From: [REDACTED]
Sent: 15 February 2026 12:25
To: Cllr Tony Austin; Cllr Susan Bibby; Cllr Ian Brown; Cllr Stella Brunskill; Cllr Mark French; cllr.michael.graveston@ribblevalley.gov.uk; Cllr Mark Hindle; Cllr Gaynor Hibbert; Cllr Jonathan Hill; Cllr Kevin Horkin; Cllr Malcolm Peplow; Cllr James Rogerson; Cllr Kieren Spencer; Cllr Lee Street; Planning; [REDACTED]
Subject: Safer Main Vehicle Access Northern Phase of Planning Application 3/2025/0997
Attachments: access plan.jpg

We are writing to you all to ask for you to consider a safer option for the main and only vehicle access to the northern phase of the proposed development, planning application 3/2025/0997.

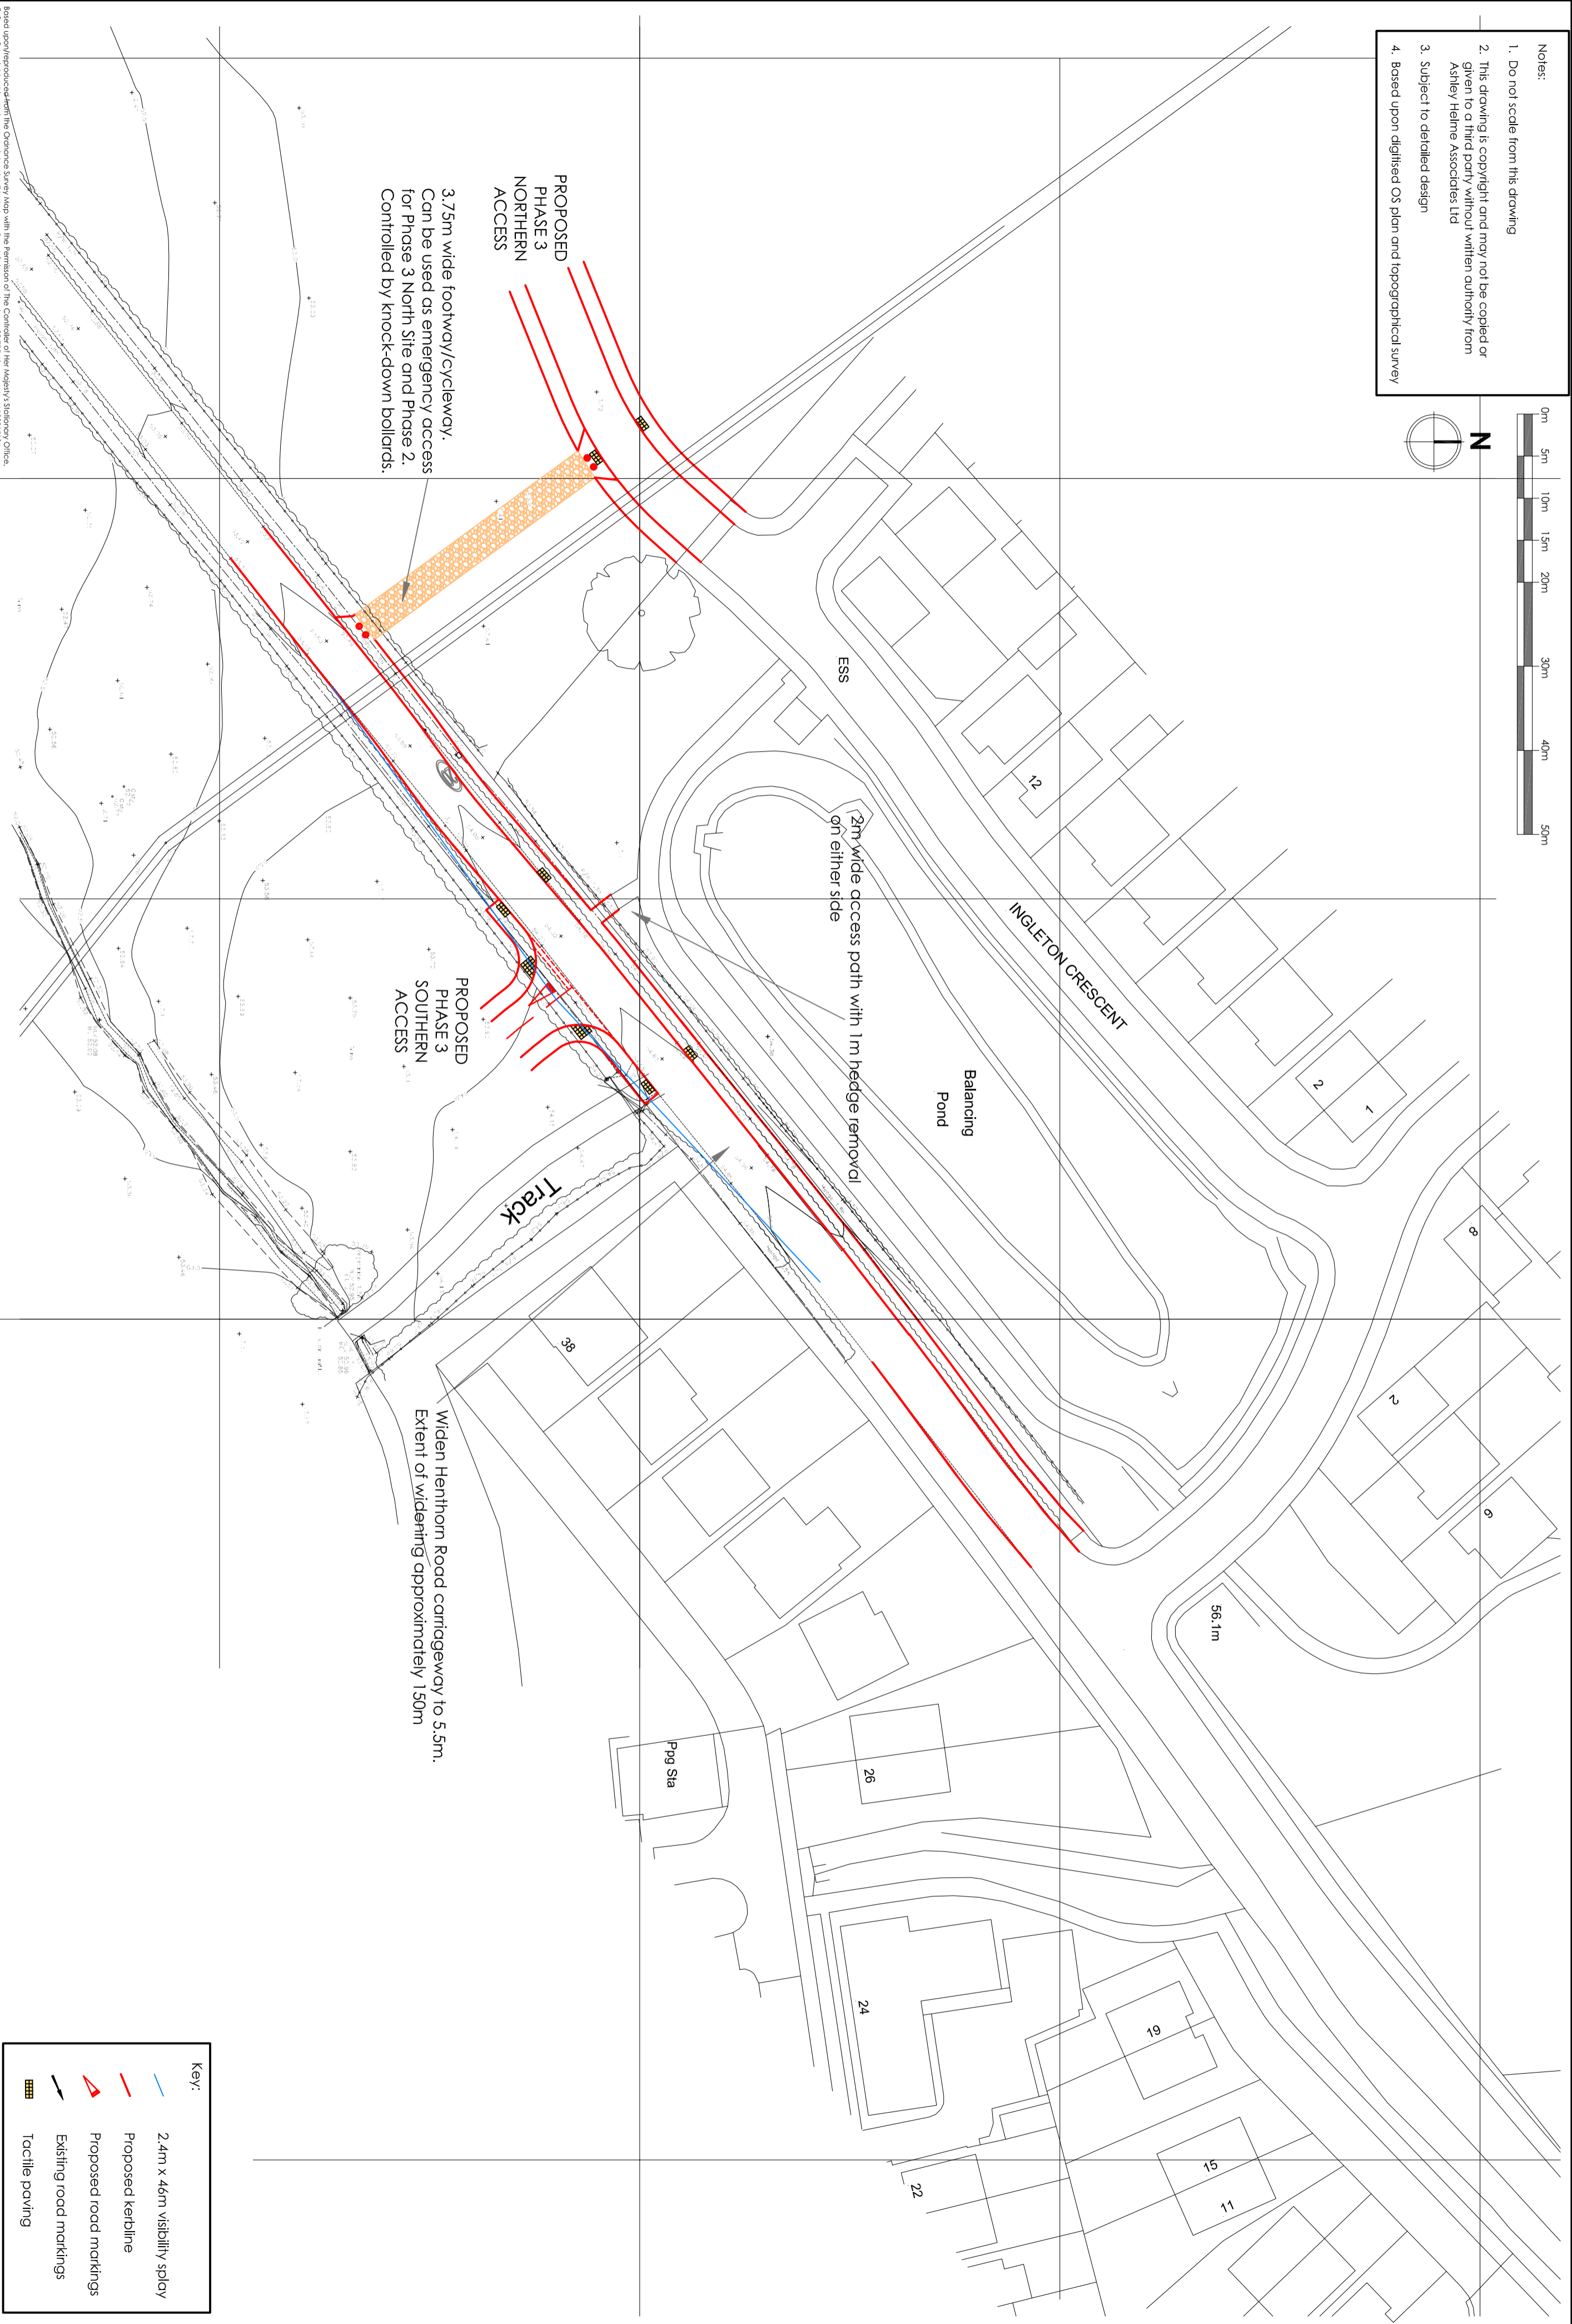
The safer option is to use the wider emergency exit/cycle path directly from Henthorn Road currently on the proposed plans. (See attached, orange area).

Ingleton Crescent and Waterfall Gardens are not roads fit for the purpose of an additional circa 70 cars traversing it as the main and only vehicle entrance to this proposed development of 35 houses.

Ingleton crescent is a narrow road with a dog leg at it's entrance (where two cars cannot fit side by side at the same time) leading to a cul-de-sac. It runs along a water filled SuDs/pond; an area filled with wildlife, ducks, herons and deer etc. The ducks and deer roam freely around the pond and the ducks (often 40 in number) wander in/on the road Ingleton Crescent. Families with young children regularly come from the local area to feed these ducks and many pedestrians walk around the path along Ingleton Crescent walking their dogs. Young children also visit playing on the footpath and on the road Ingleton Crescent.

A much safer and logical option, for the main and only vehicle access, is to use the already proposed wider emergency/cycle route that is accessed direct from Henthorn Road.

As you can see in the proposed plan it is a straight and direct route into the site from Henthorn Road and negates the need to traverse through already residential Waterfall Gardens and the dog legged narrow Ingleton Crescent. It is not bordering on an area where wildlife and pedestrians frequently visit from the local area.
